Rezoning Transportation Analysis

Petition Number: 2020-062

General Location Identifier: Tax ID 04545103

Date	Description
05-08-20	First Review (TVT)

SHEET NUMBER
RZ-1

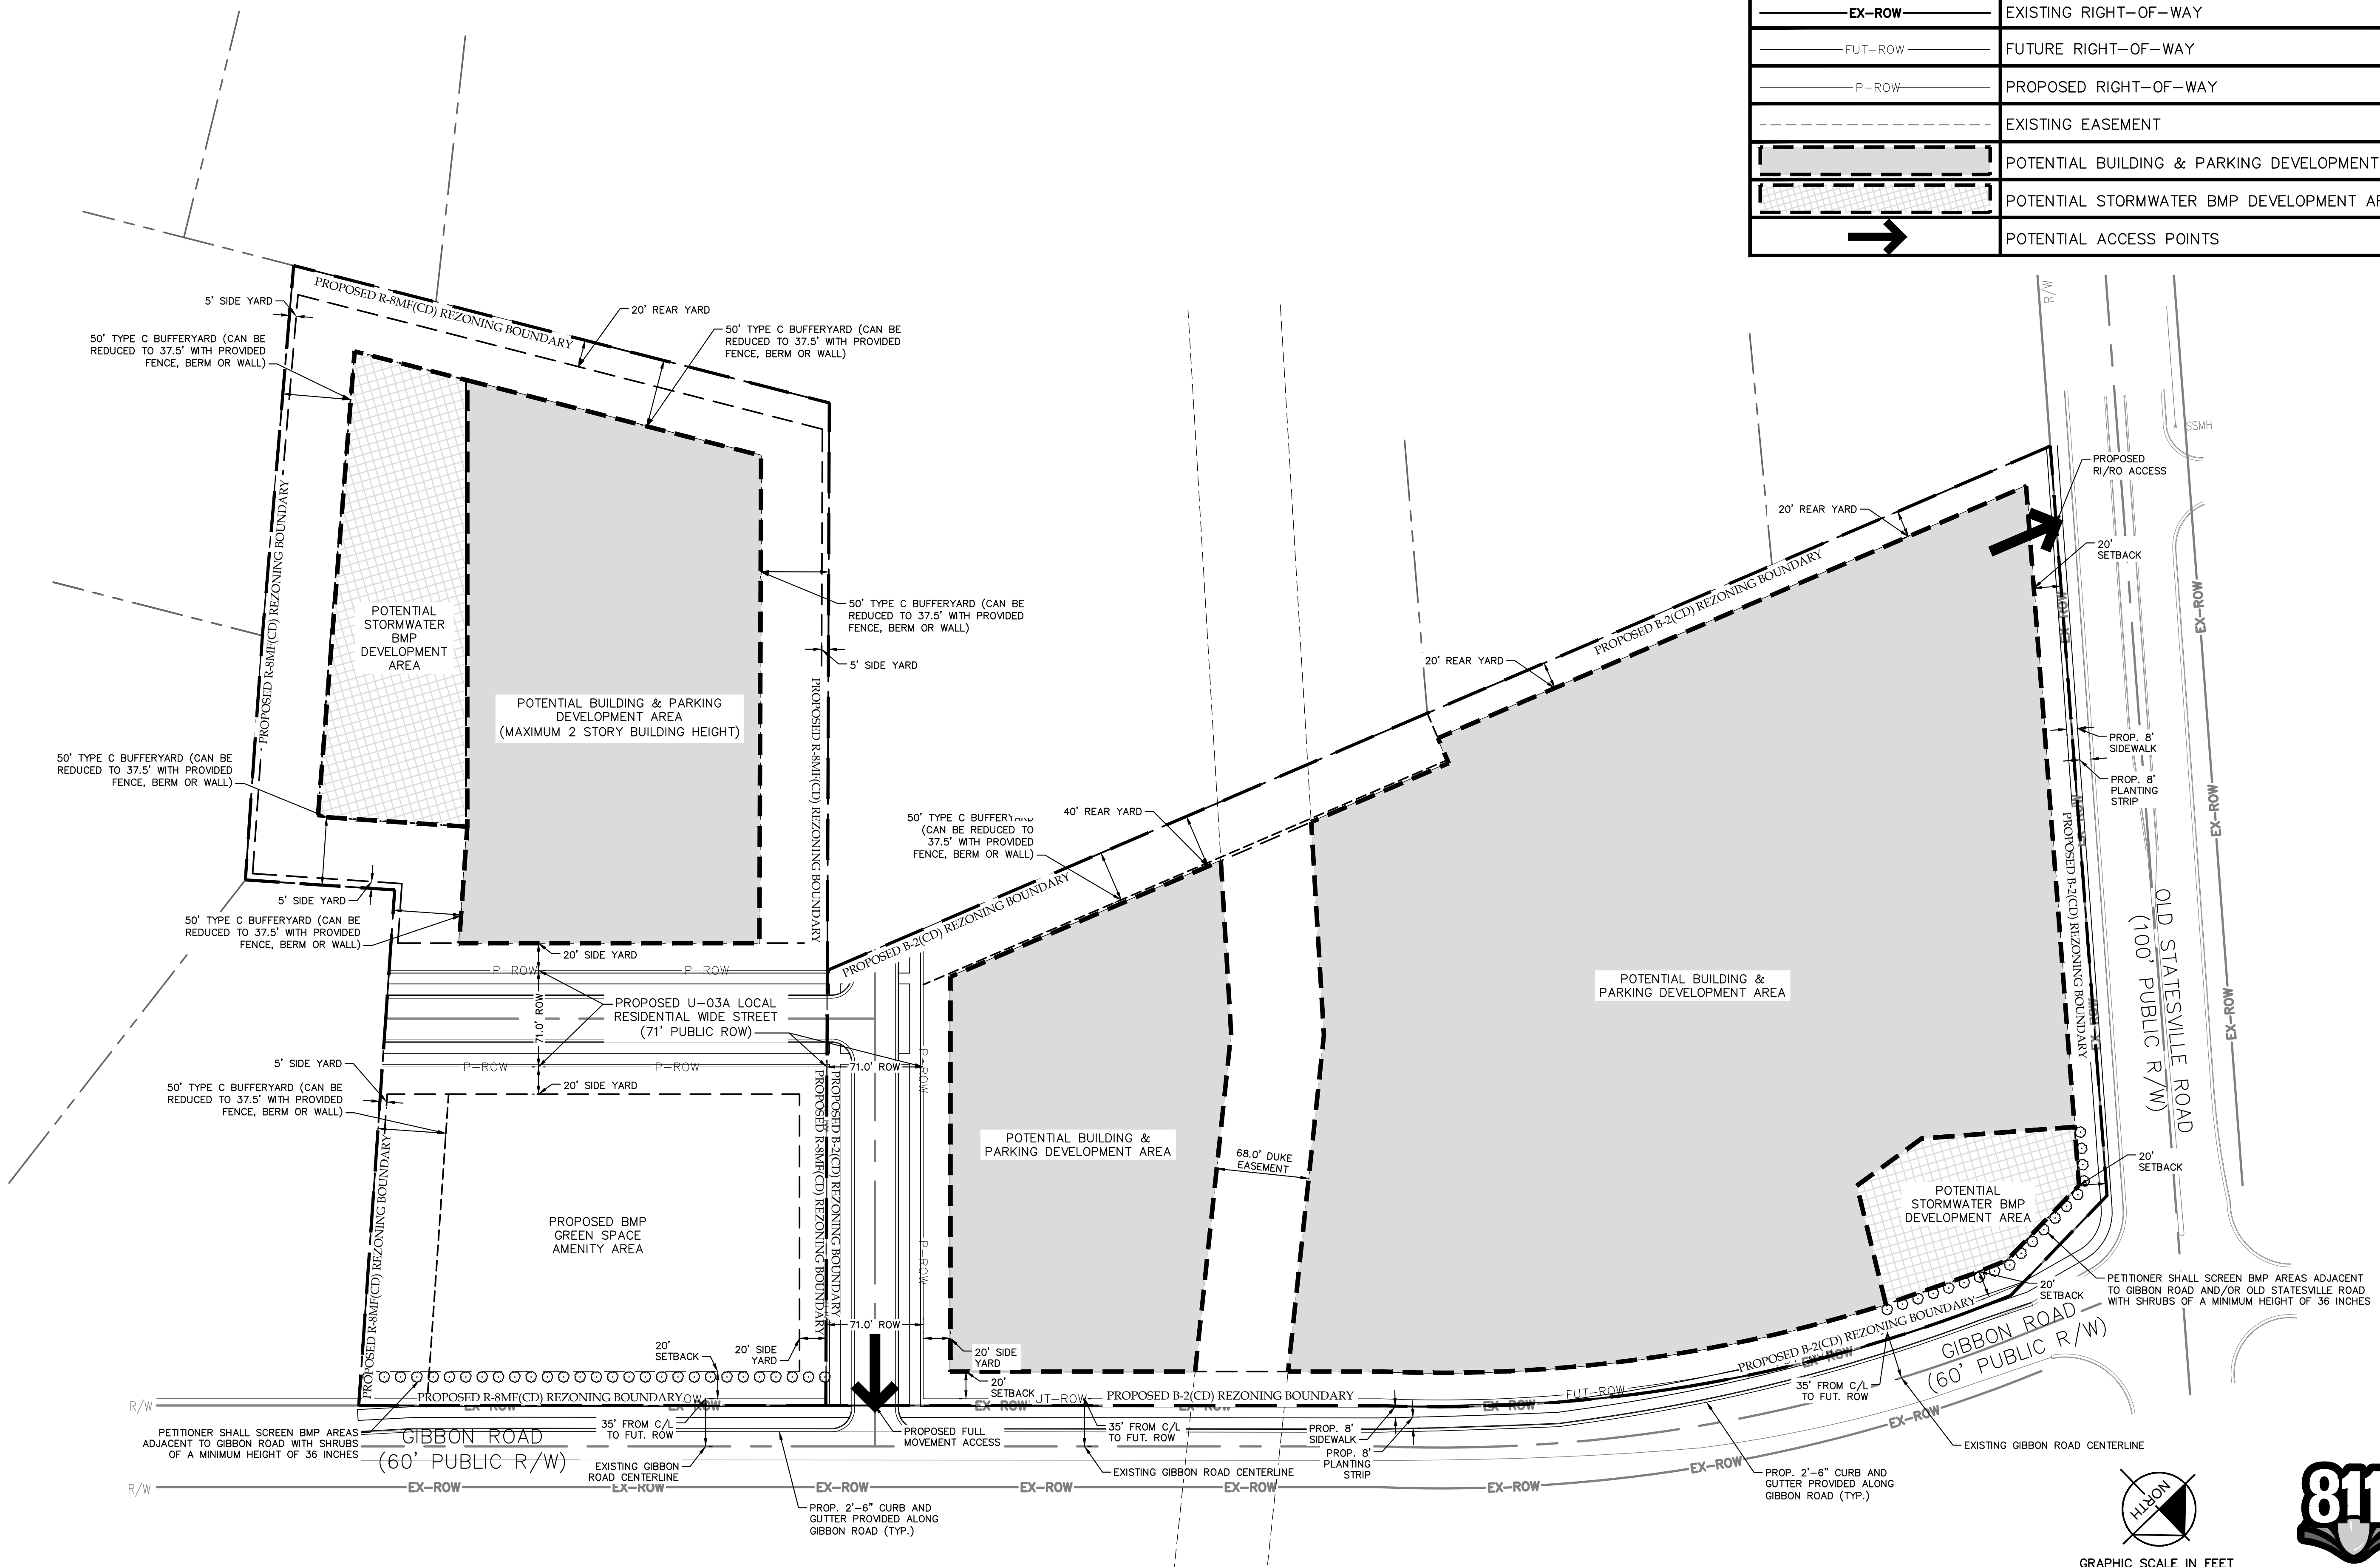
There is existing curb and gutter, standard planting strip and sidewalk on Old Statesville Road. On Gibbon Road there is no curb and gutter or sidewalk. CDOT is requesting the petitioner to submit a traffic impact study because the site generates more than 2500 daily trips. In addition, we request the petitioner to change from a conventional to a conditional site plan.

- Traffic Study** A Traffic Impact Study is necessary for the complete review of this petition due to the site generation of more than 2500 daily trips. The petitioner can change the zoning or provide a conditional site plan to better define the proposed trip generation for the site.
